This application is to powder coat, to BS 1/22 Part 16 (BS 6497) (providing an architectural coating of 60 microns), the proposed fence in:

Barnsley Buildbase - Elevations

Barnsley Buildbase - Elevations

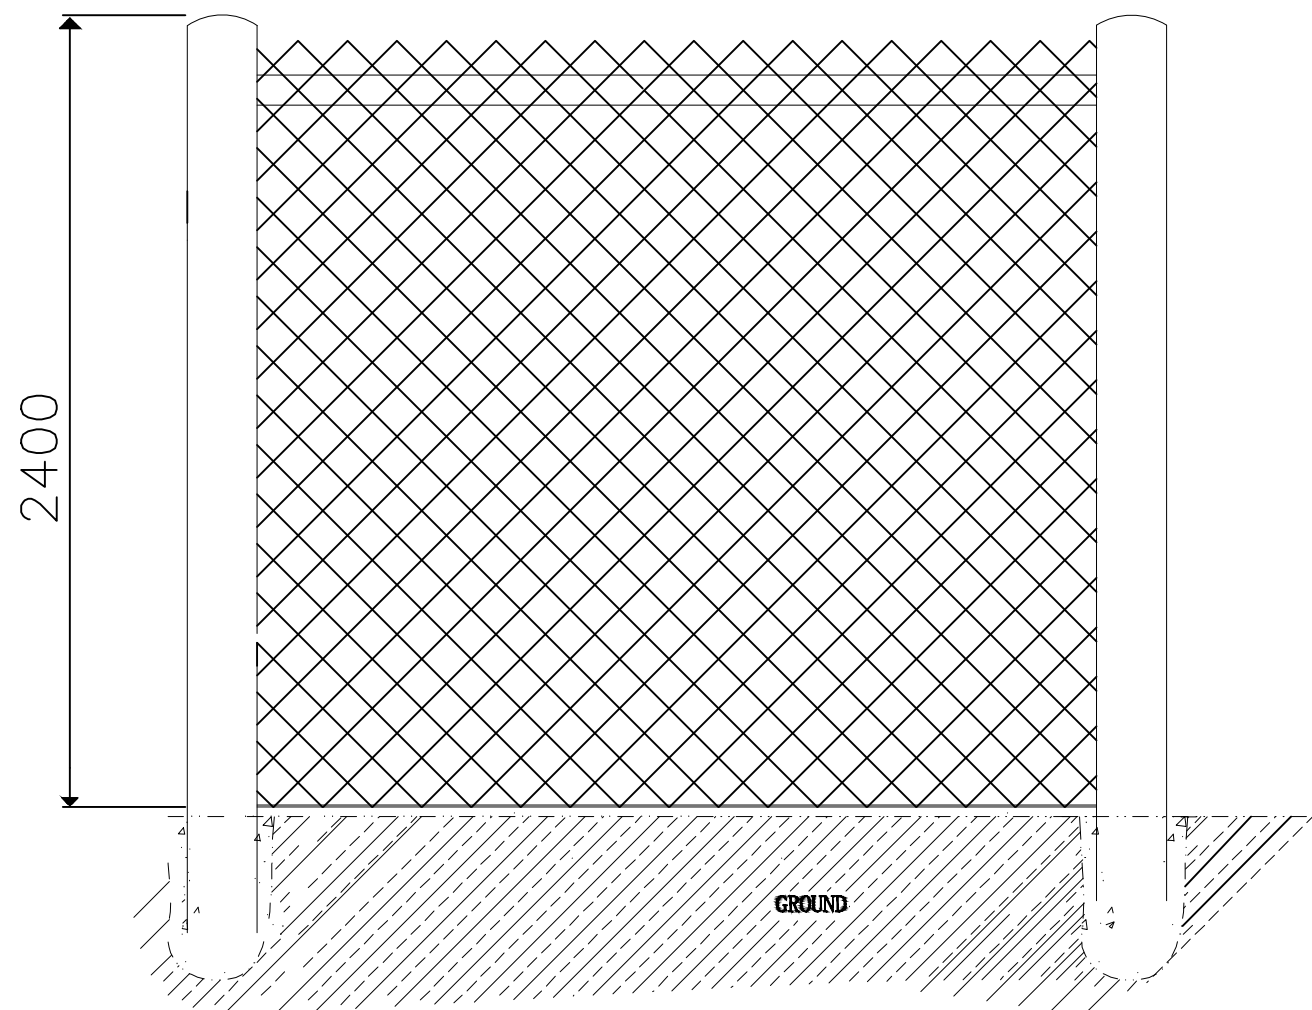
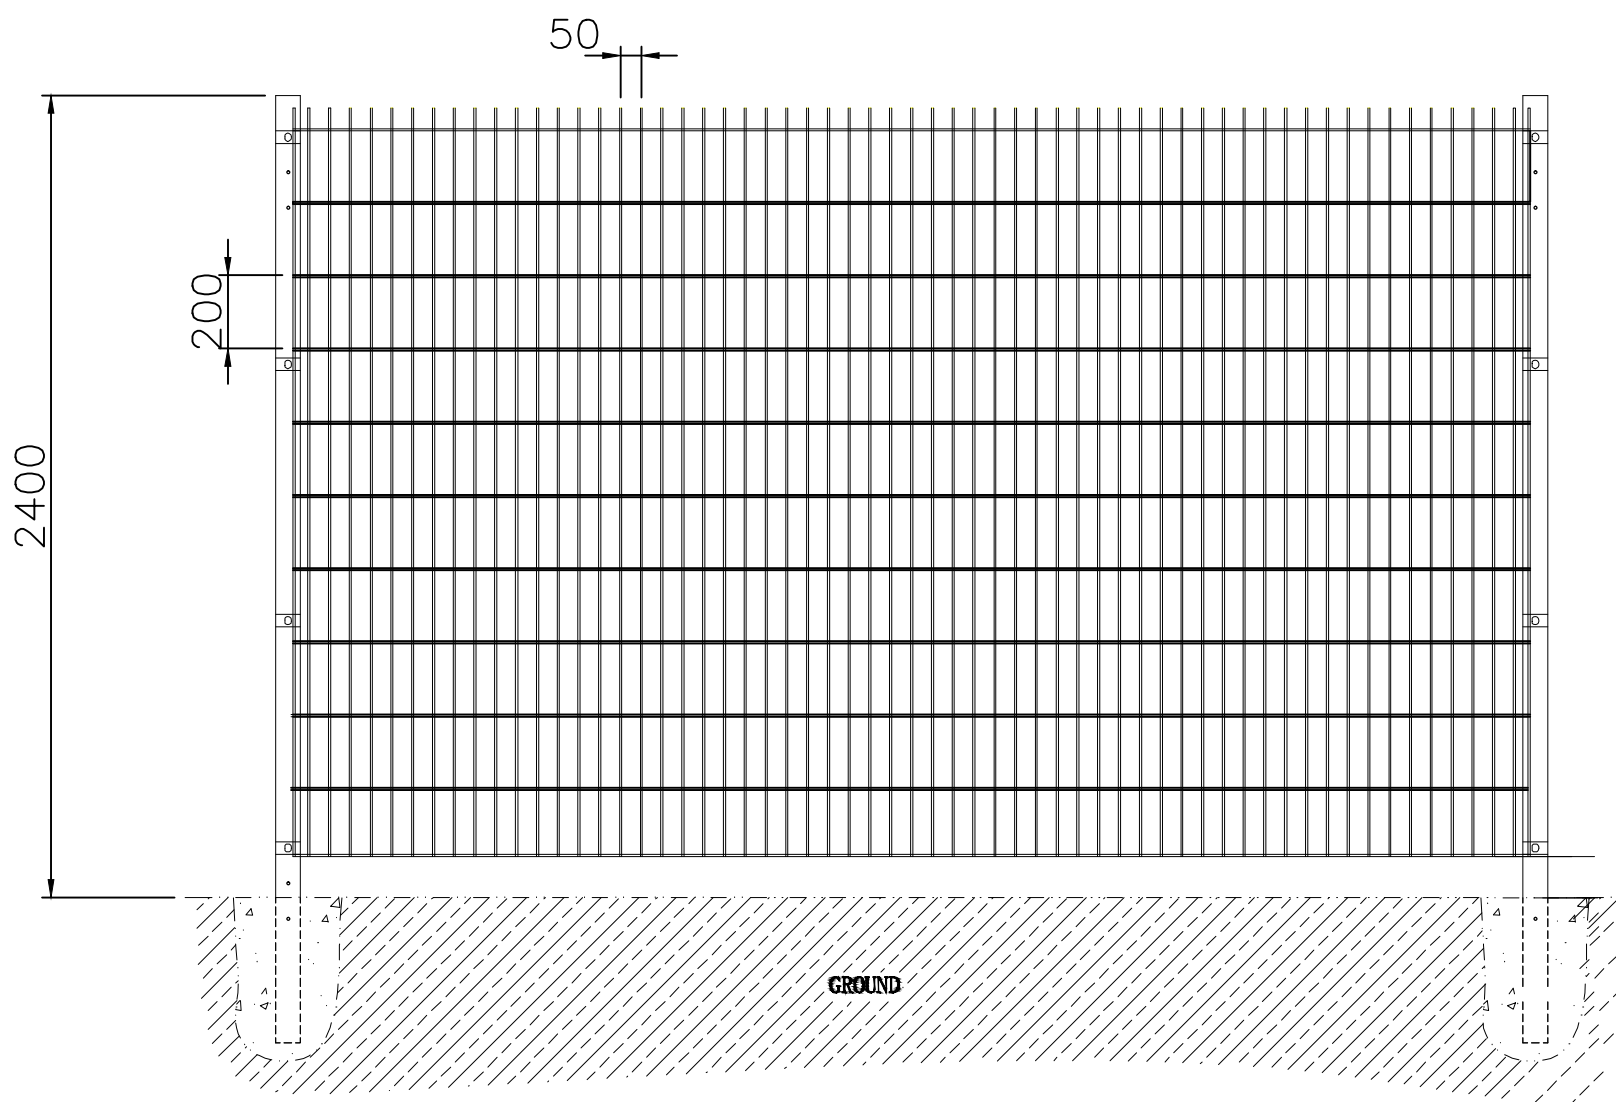
*amendment to colour of fence.

- RAL 9023, Pearl Dark Grey
